DESIGN RESPONSE

20009DA

104-116 REGENT STREET
REDFERN

09 JUN, 22

1 Plant Level
Floor Plan 1 : 200

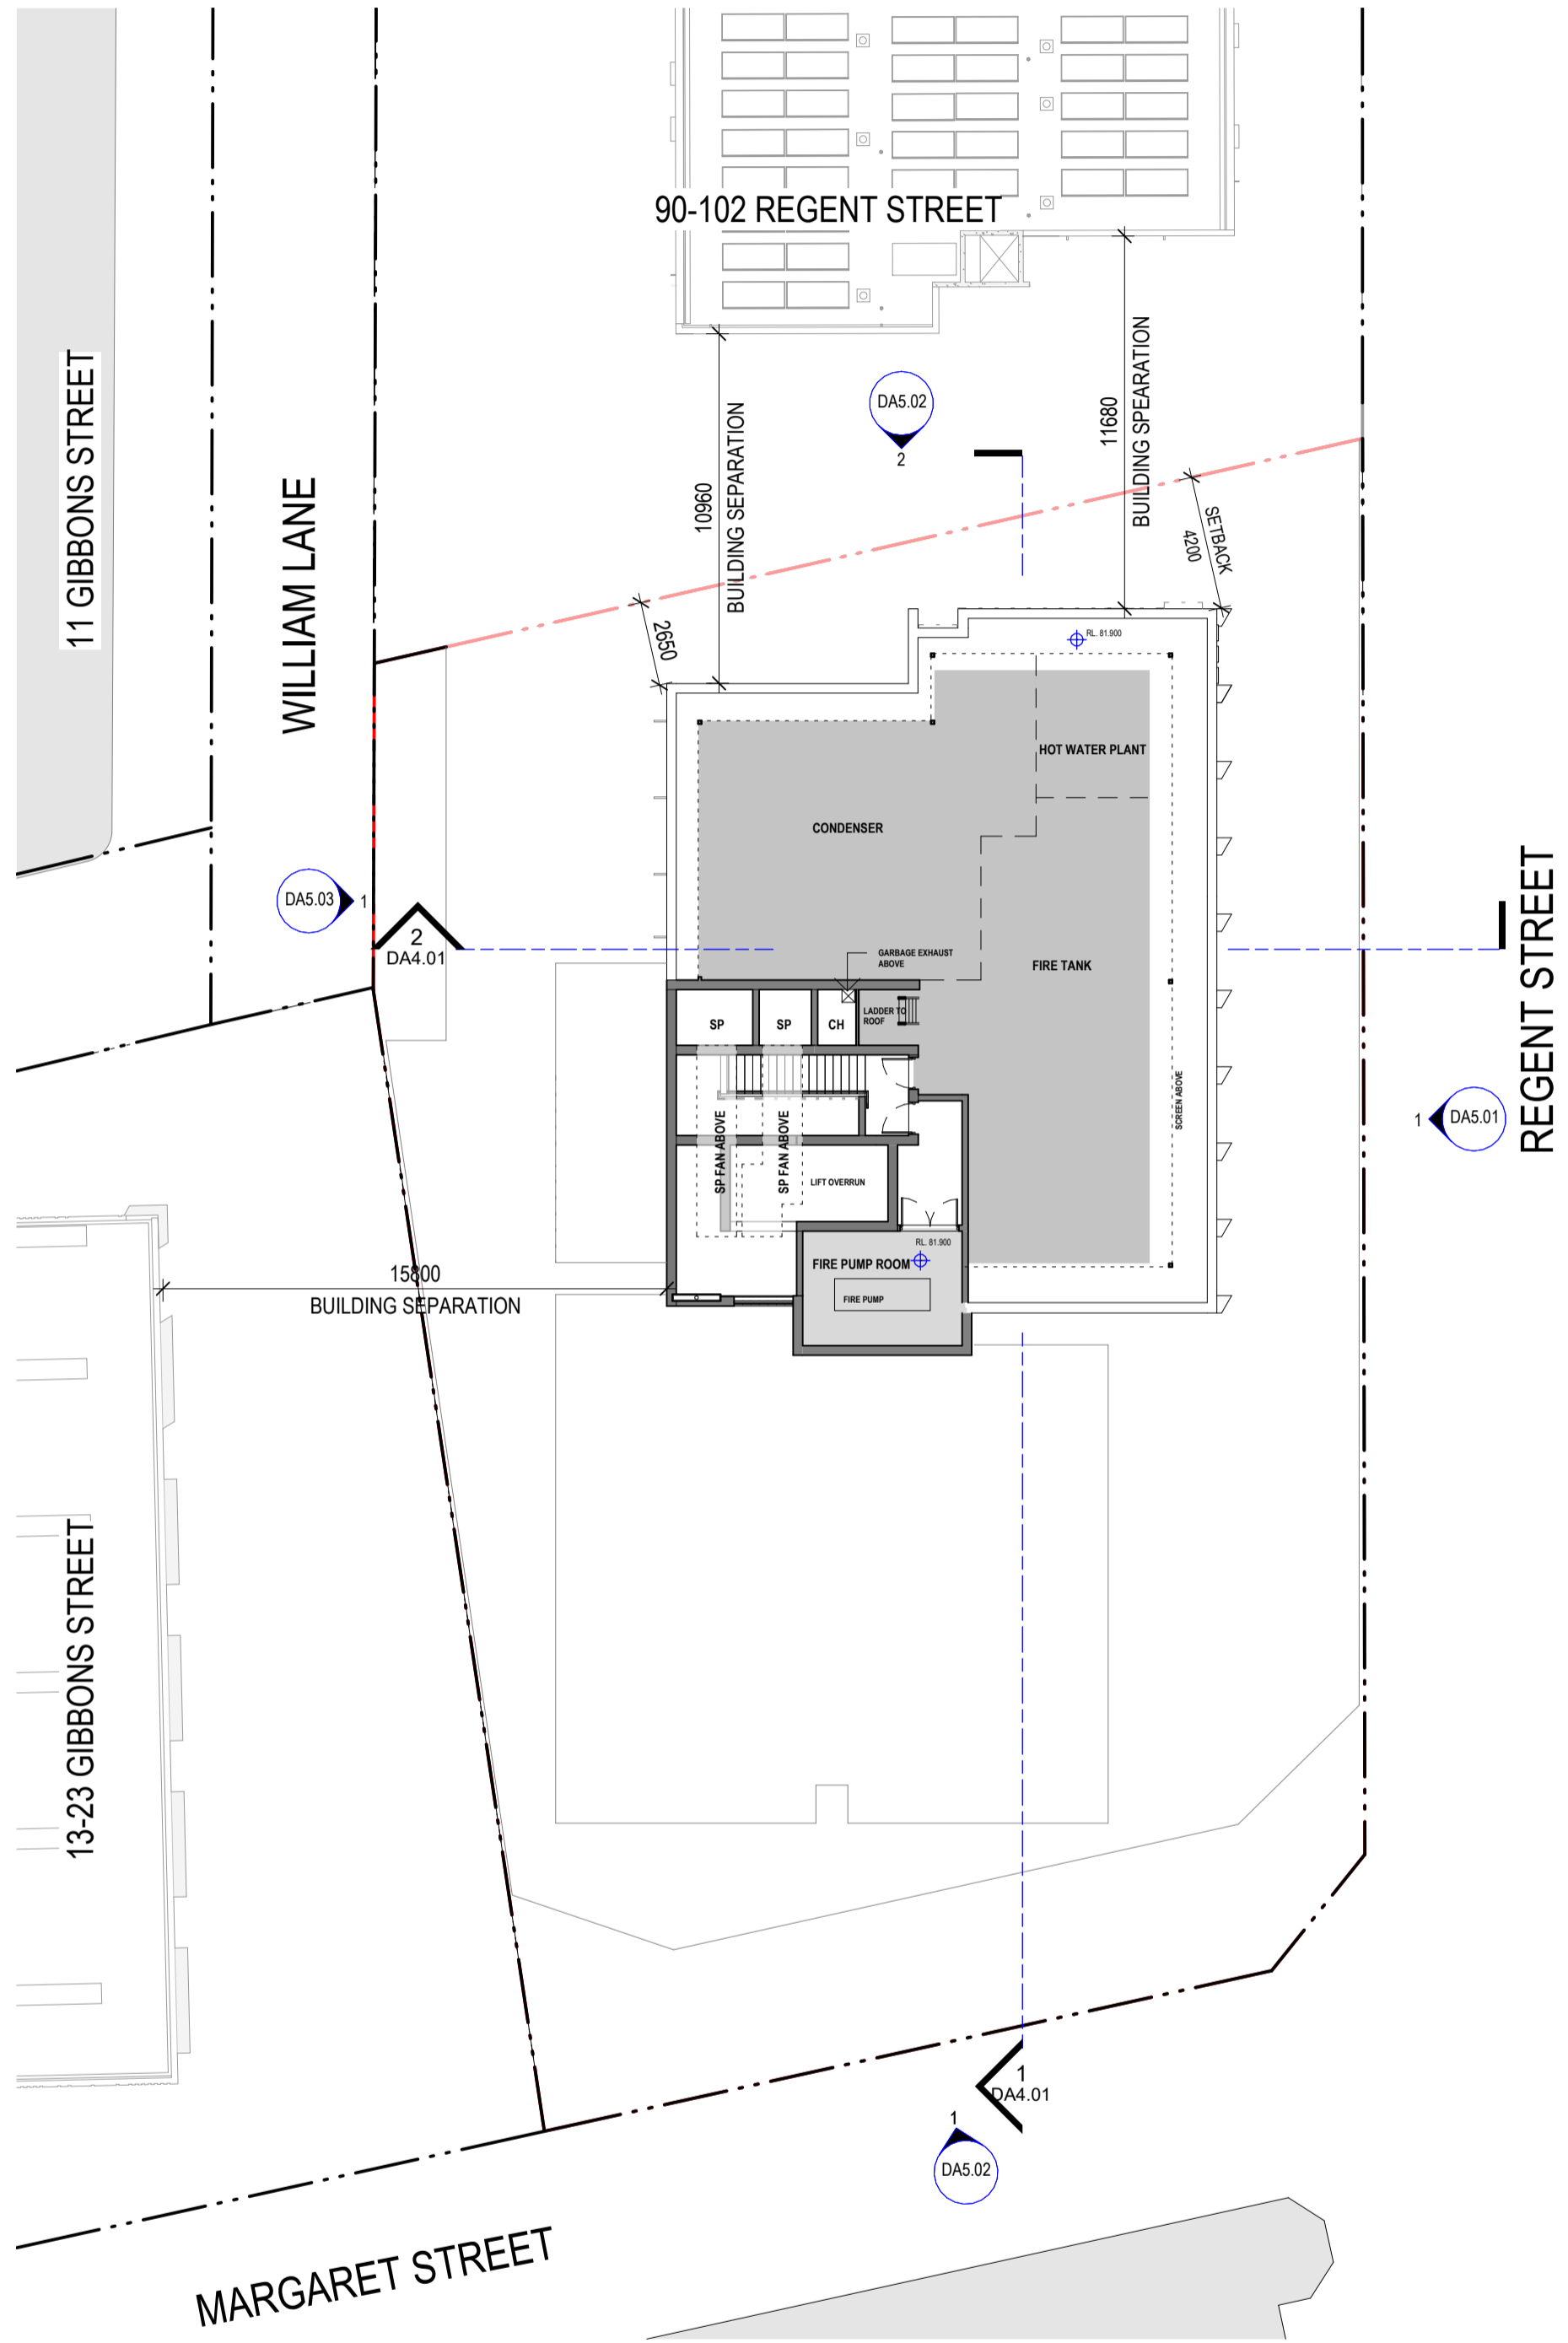
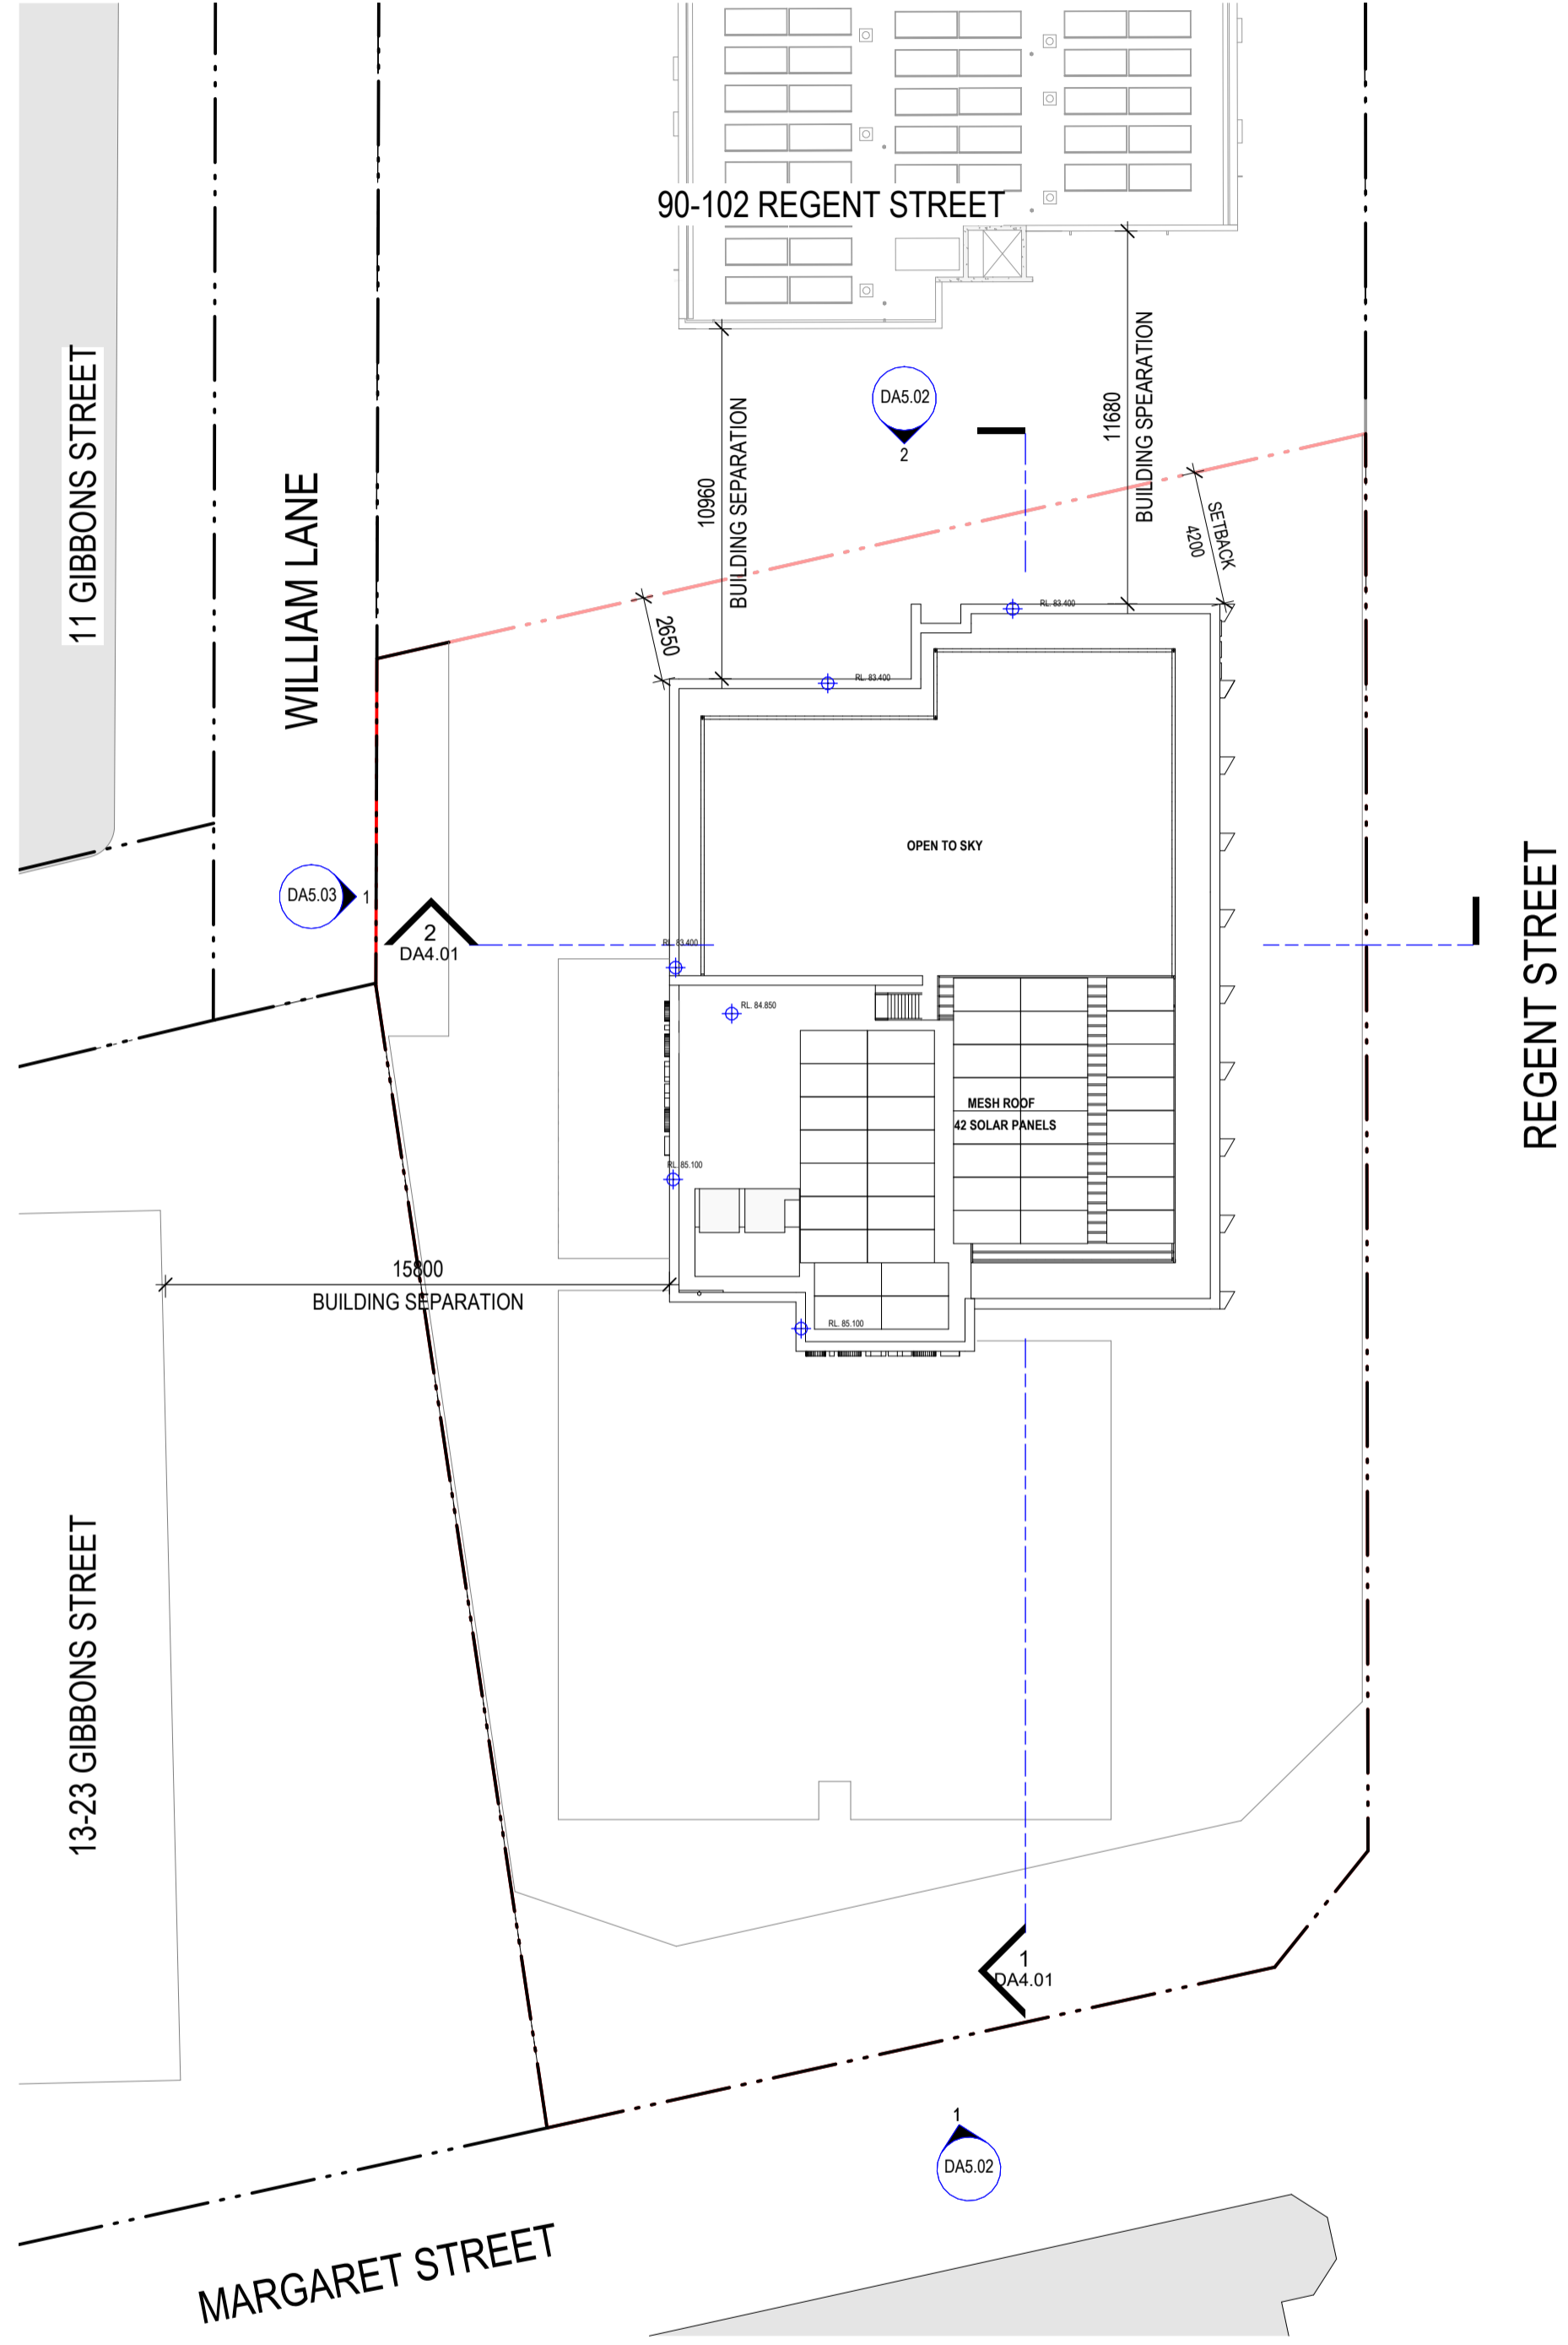
Reduce the height of the building to comply with the 18-storey height limit (noting the proposal currently reads as a 19-storey building) and ensure roof top plant is integrated into the design of the building or appropriately screened

The site prescribes a height of buildings of 18 storeys under SEPP (State Significant Precincts) 2005. The proposal does not comply with the height control and presents a 19-storey development as plant is distributed across the full extent of the tower and contributes to a whole storey of visible bulk and scale. The maximum height is also higher than the development at 90-102 Regent Street, despite being lower in the street due to the fall of the topography.

The City strongly recommends that the maximum height of the tower be lowered to match the neighbouring development, with plant to be designed into an 18-storey tower or substantially setback from the perimeter of the tower to reduce bulk and scale. The development also provides a consistent single height podium, which makes the site appear as monolithic with no correlation to the topography and fine grain character of the locality.

Significant changes have been made to the siting and design of the roof-top plant and equipment to minimise its potential visual impact and avoid the perception of this forming an additional storey. The proposed changes have included:

- The rooftop plant setback from the perimeter. Refer previous and amended roof plans showing the plant extent in grey (refer to figure 2)
- Parapet height reduced from 3.55m to 1.5 m(refer to figure 1)
- Metal louvre screens provided to conceal the visible portion of the plant equipment behind.

The change has also brought the height of tower lower than 90-102 Regent St (refer to figure 1)

1 Regent st Elevation
Elevation 1:200

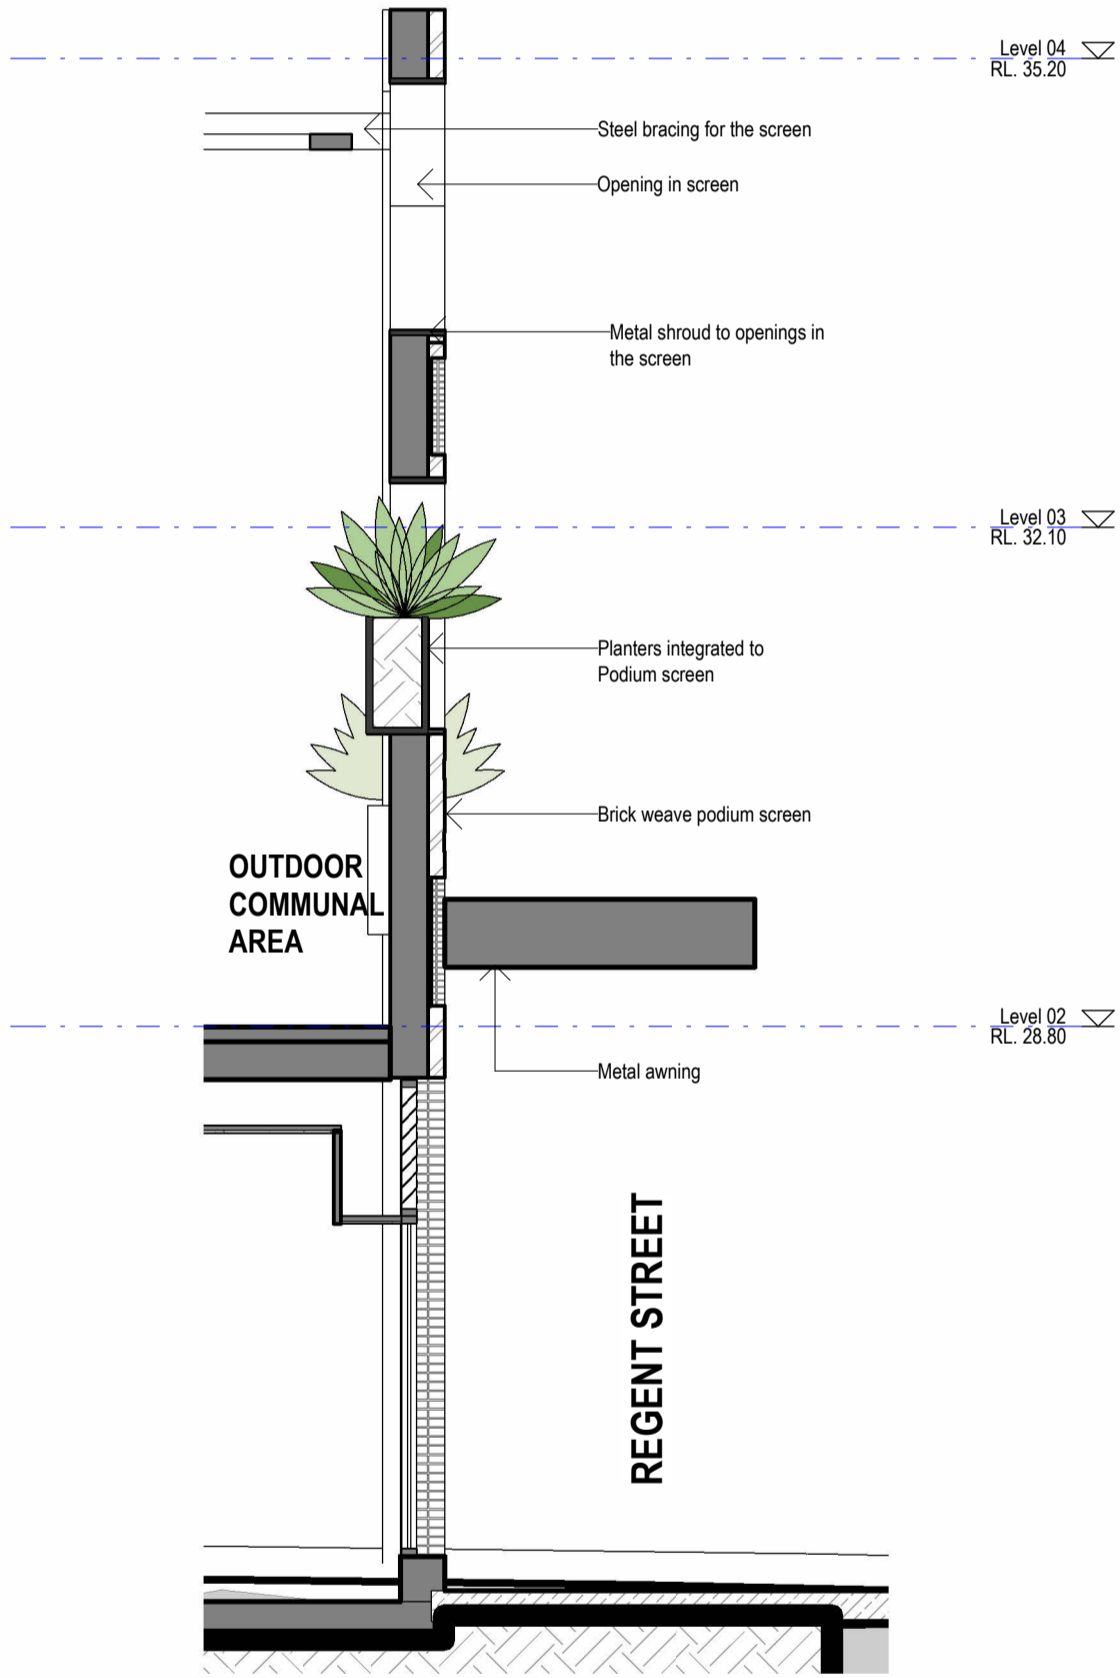
Further details is requested in the form of 1:20 wall sections and elevations detailing the brick and construction elements of the podium and screen. The quality, materiality and finishes of all ground level services is recommended to match the façade quality and not be the contrasting paint finish to the brick colour.

Refer DA 5.01 and DA 5.03 providing detailing of brick on the elevation and 1:20 wall section.
